Planning Application Ref: Y/61/19/PL

Location: Yapton Metal Company, Burndell Road, Yapton, BN18 0HP

Description of works: Application for variation of condition imposed on planning permission Y/53/16/PL relating to condition no.2 - amendment to site layout. This application affects the setting of a Listed Building

Mark Warwick
Tree Officer / Parks and Greenspace Team

Site Plan (Proposed) 1:200

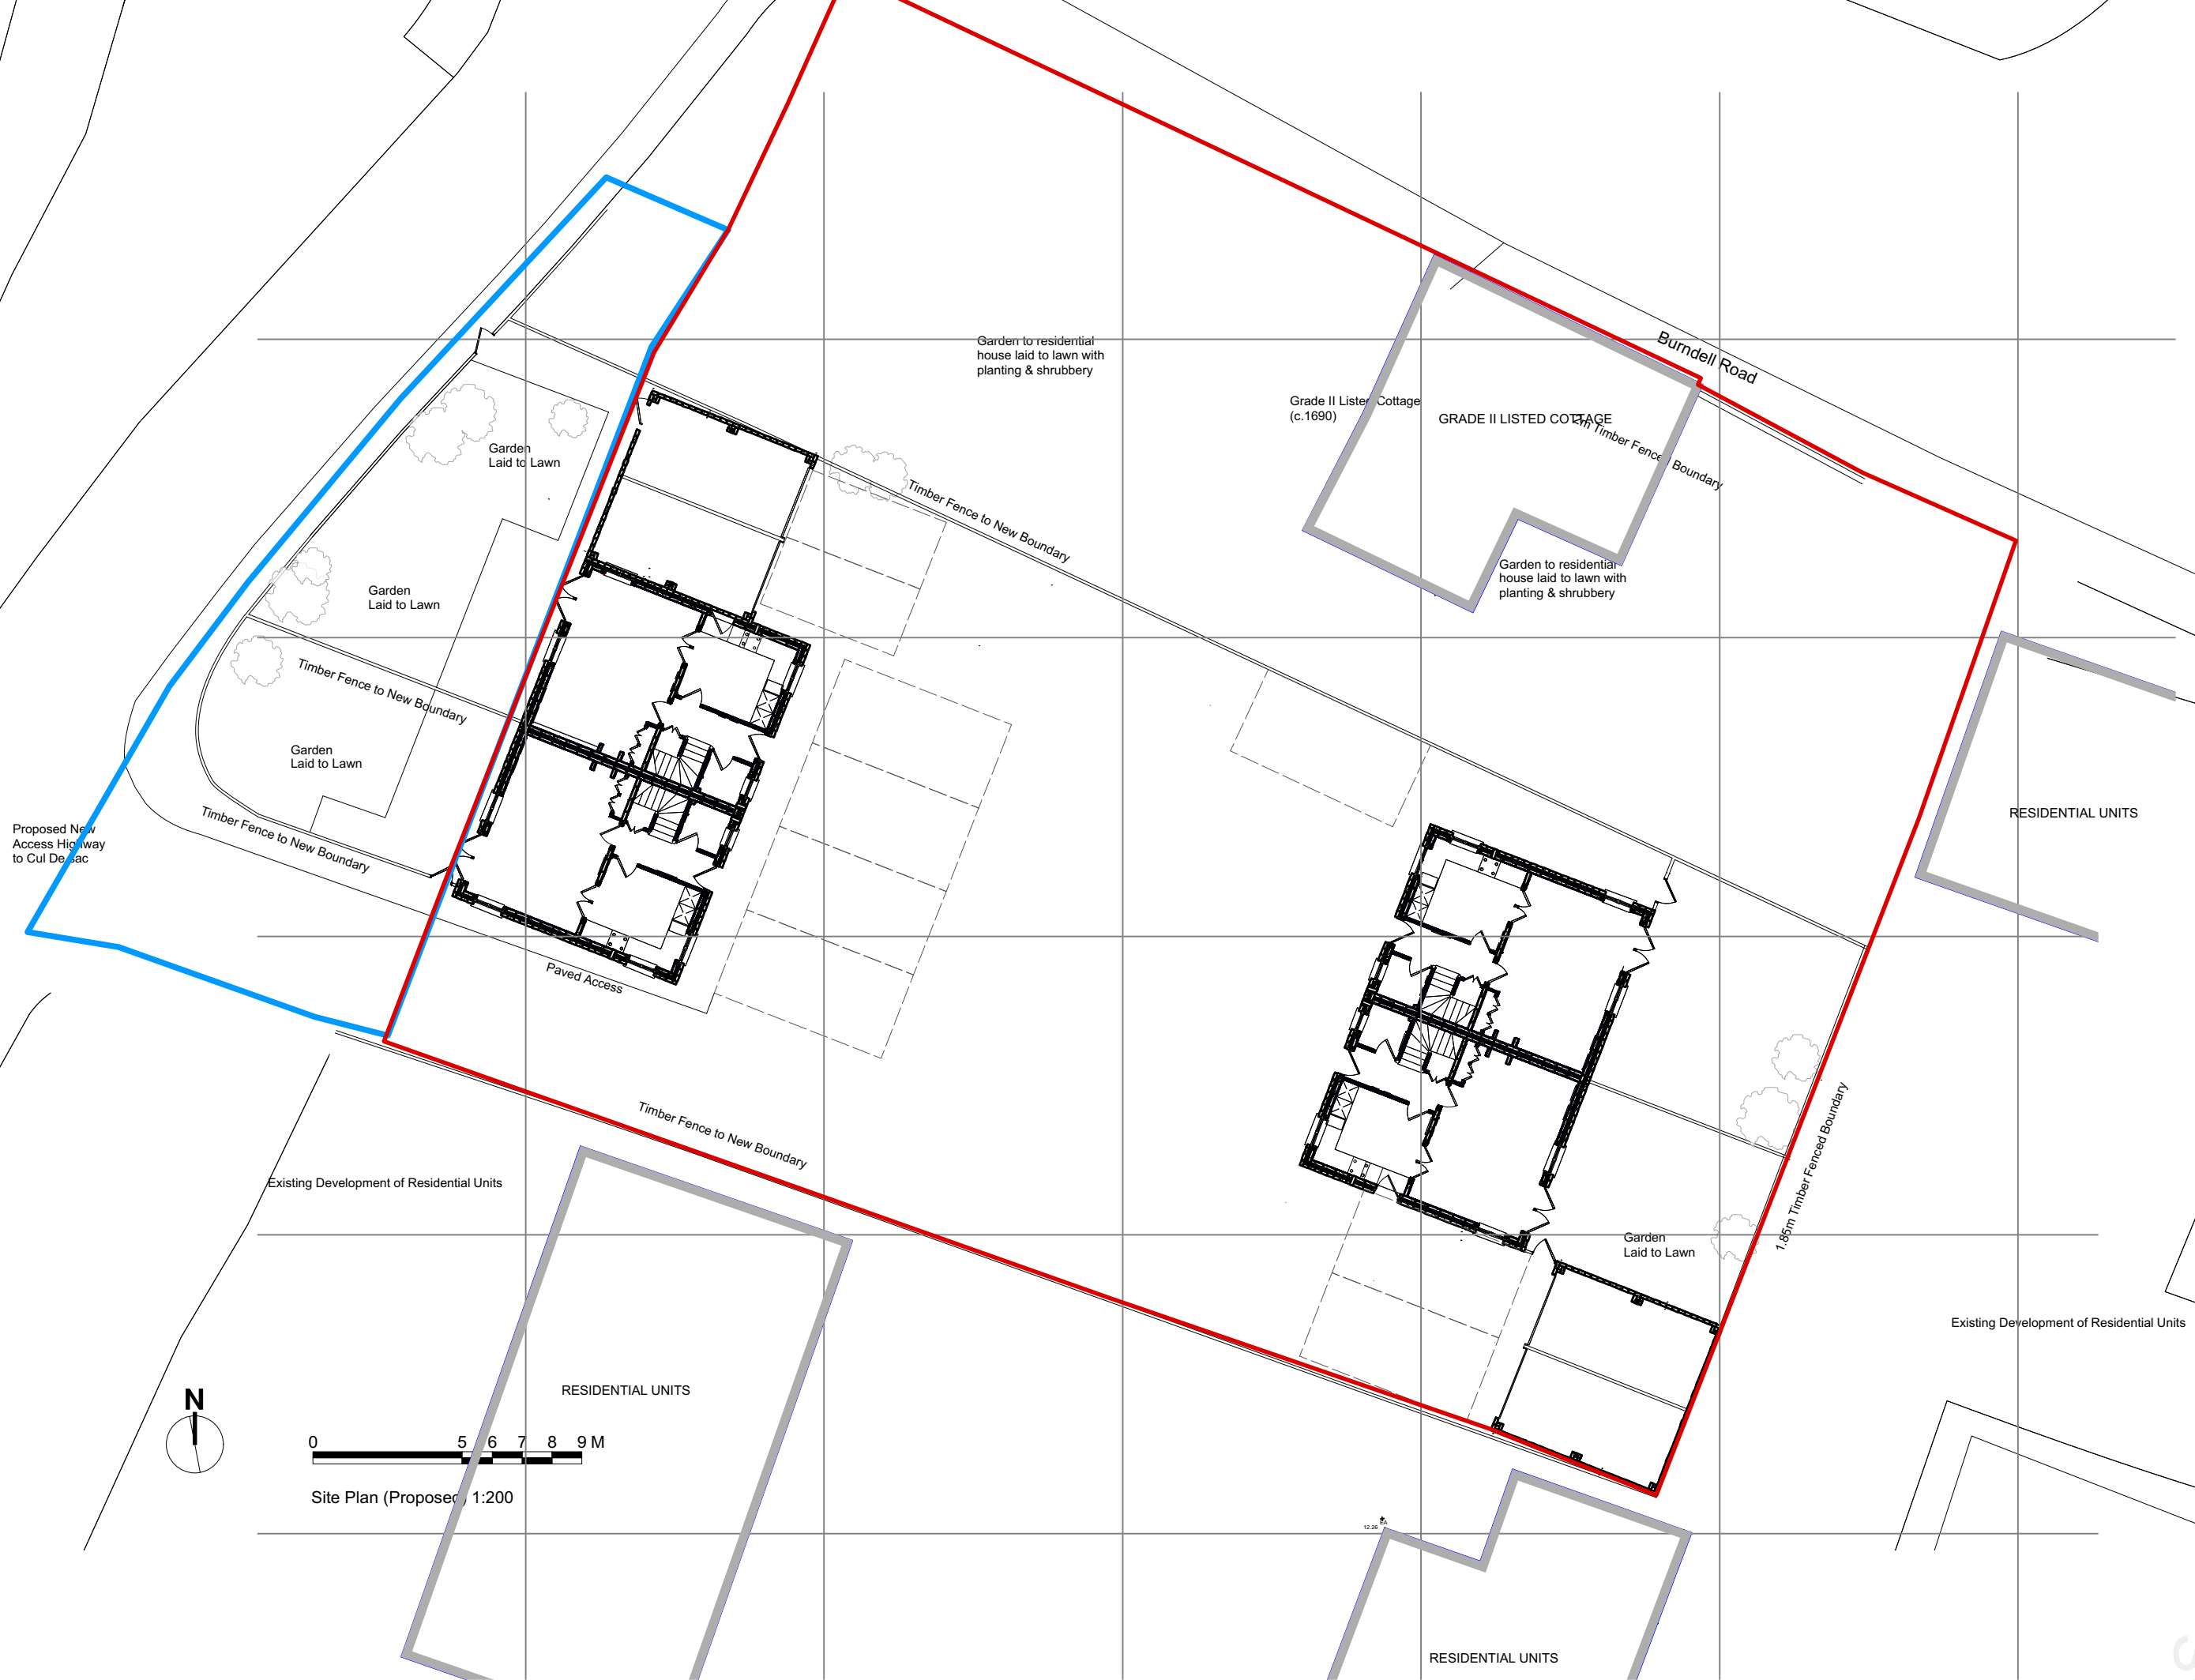
- The original application provided for a soft landscaped buffer zone between the parking spaces north of Block A and a blockwork wall boundary to the adjoining plot. In theory, this allowed for the retention of sycamore (T6) – a Category B mature tree.
- The applicant draws attention to an error within the plans approved in permission Y/108/15/PL, in respect of the inaccurate plotting of trees in relation to the site. This appeared to have been resolved to our satisfaction (Y/53/16/PL).
- It is not clear to me how exactly that error had arisen, although it is clearly disappointing to have now lost significant tree cover which may have made a significant contribution to both the new development and surrounding area.

- The removal of numerous trees (T4, T6, T8, T9, T10 and T11) has occurred, most of which were originally identified for retention. T4 (approved) and T6 appear to be the only trees removed to directly facilitate the development although in the case of the latter this could probably have been avoided with adequate engineering input and tree protection measures.
- At this late stage, post-tree removal and with little confidence in the arboricultural submissions associated with the site to provide me with a historical perspective; I am unable to make a positive recommendation in response to the application other than to suggest a detailed scheme for tree planting be submitted for our consideration, to compensate for uncontrolled loss of tree cover.
